From: Contact Centre (CRM) <contact@ribblevalley.gov.uk>
Sent: 02 July 2026 08:12
To: Planning
Subject: Planning Application Comments - 3/2026/0340 FS-Case-853072642

Planning Application Reference No.: 3/2026/0340

Address of Development: 53 Riverside Clitheroe BB7 2NS

Comments: I would like to object to application 3/2026/0340 first floor extension over existing extension on the grounds that;

PROPOSED FIRST FLOOR PLAN
SCALE 1:50

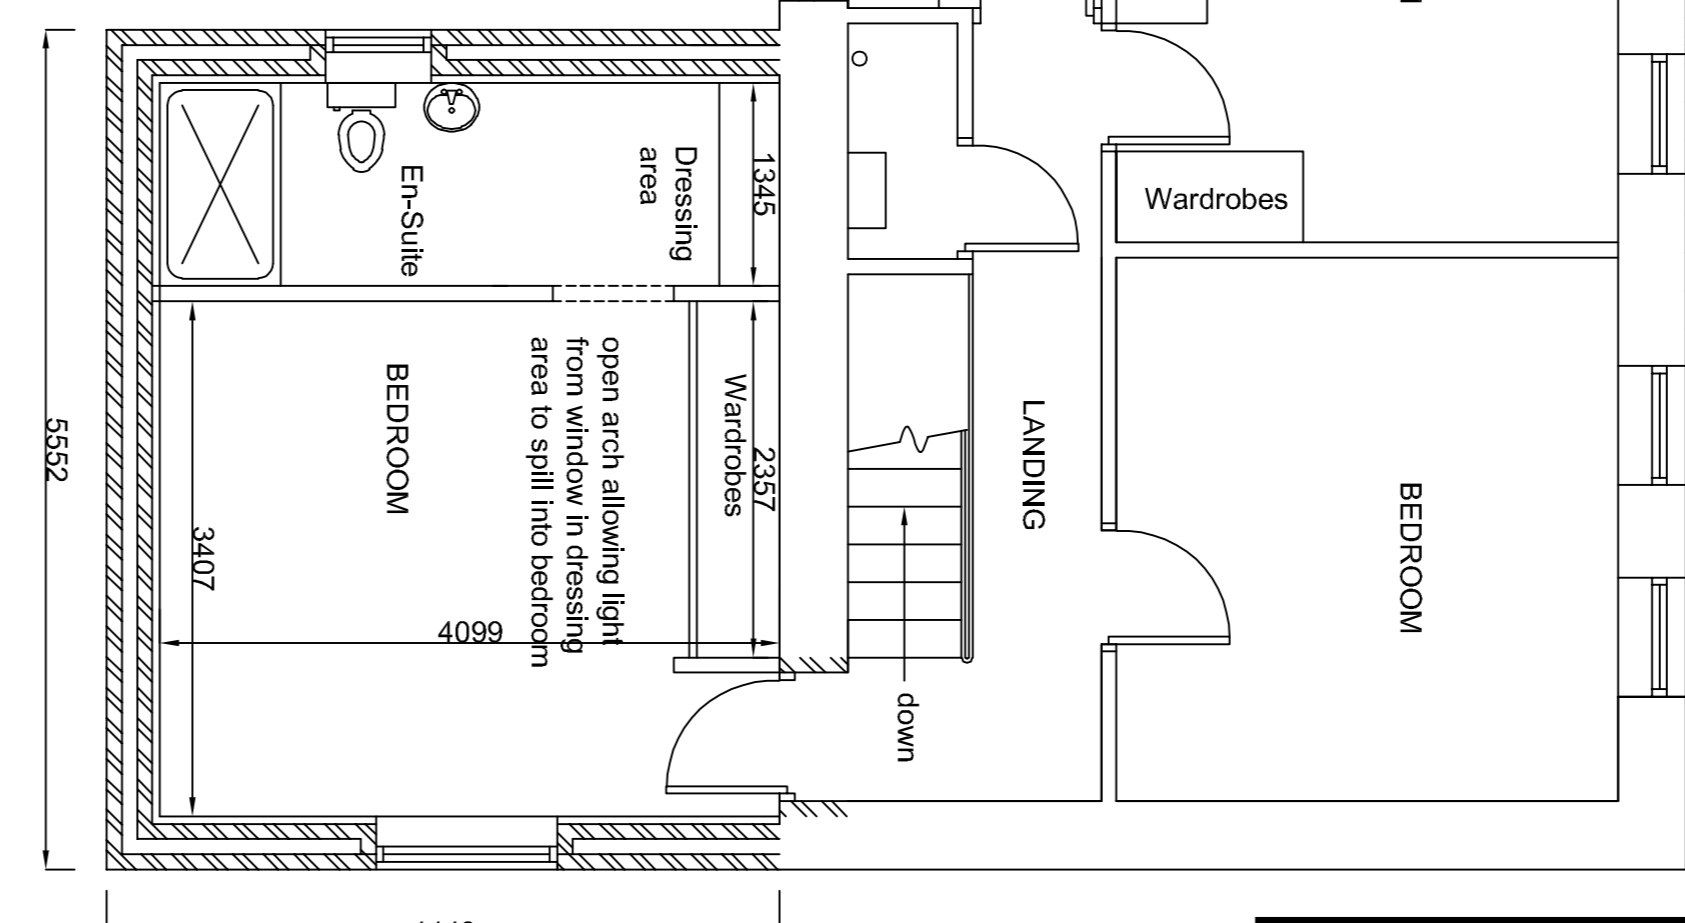
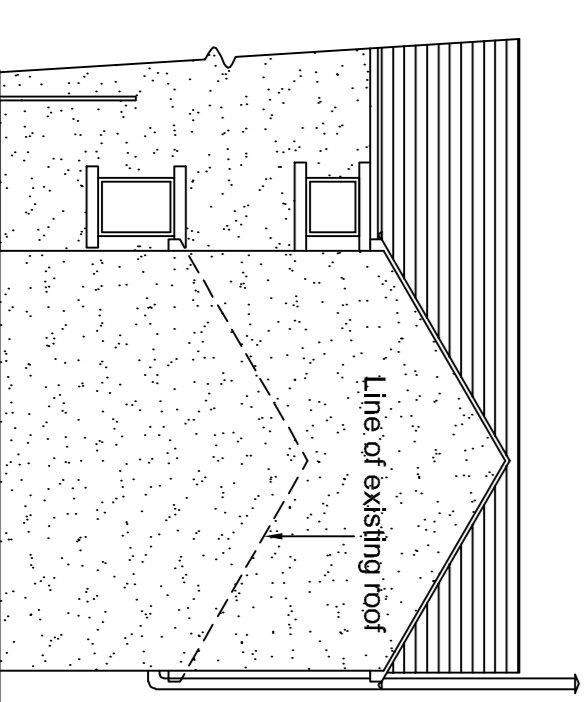
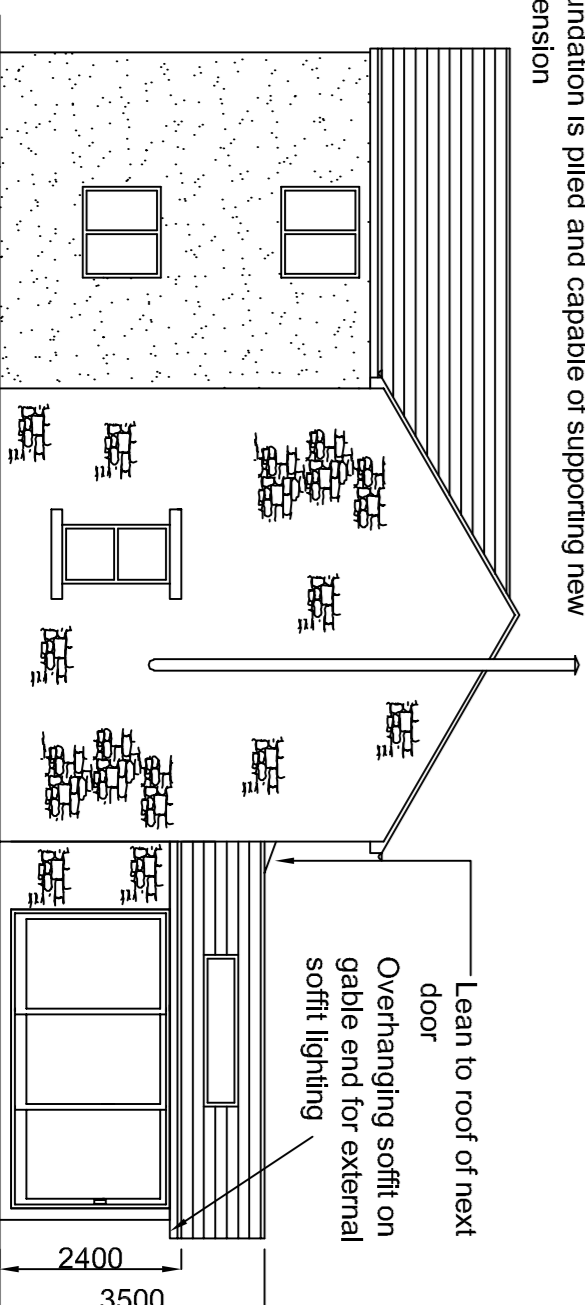
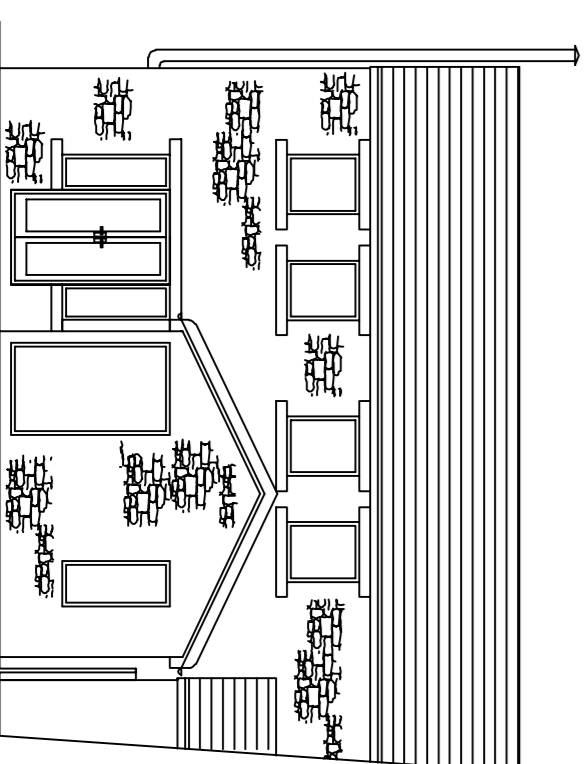
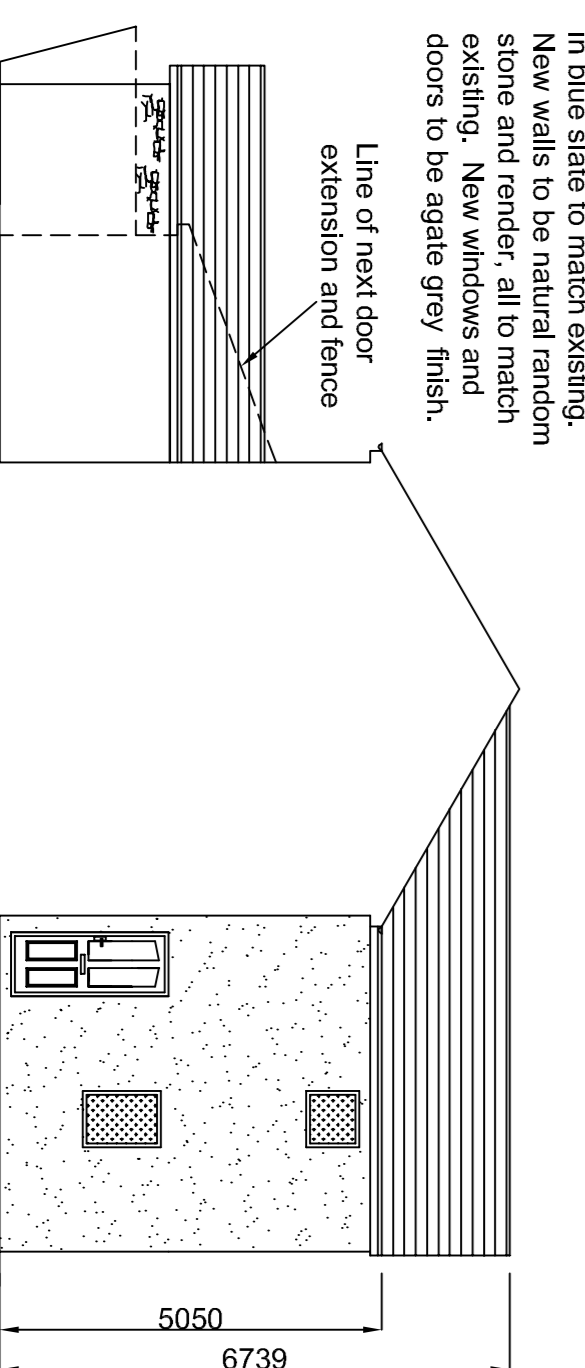
- The doubling of the extension will be overbearing, oppressive, domineering and too large and not in keeping with the openness of the area it will close the gap between the properties in direct conflict with the design principles of Policy DMG1 requirements for protecting the neighbours amenity.
- It will block light and sunlight from all neighbouring properties where they have the right to light and in particular one neighbour, where the 45-degree light test both horizontally and vertically would fail.
- The added extension is not set down from the main roof ridge therefore it doesn't ensure a visible distinction between the extension and the main house.
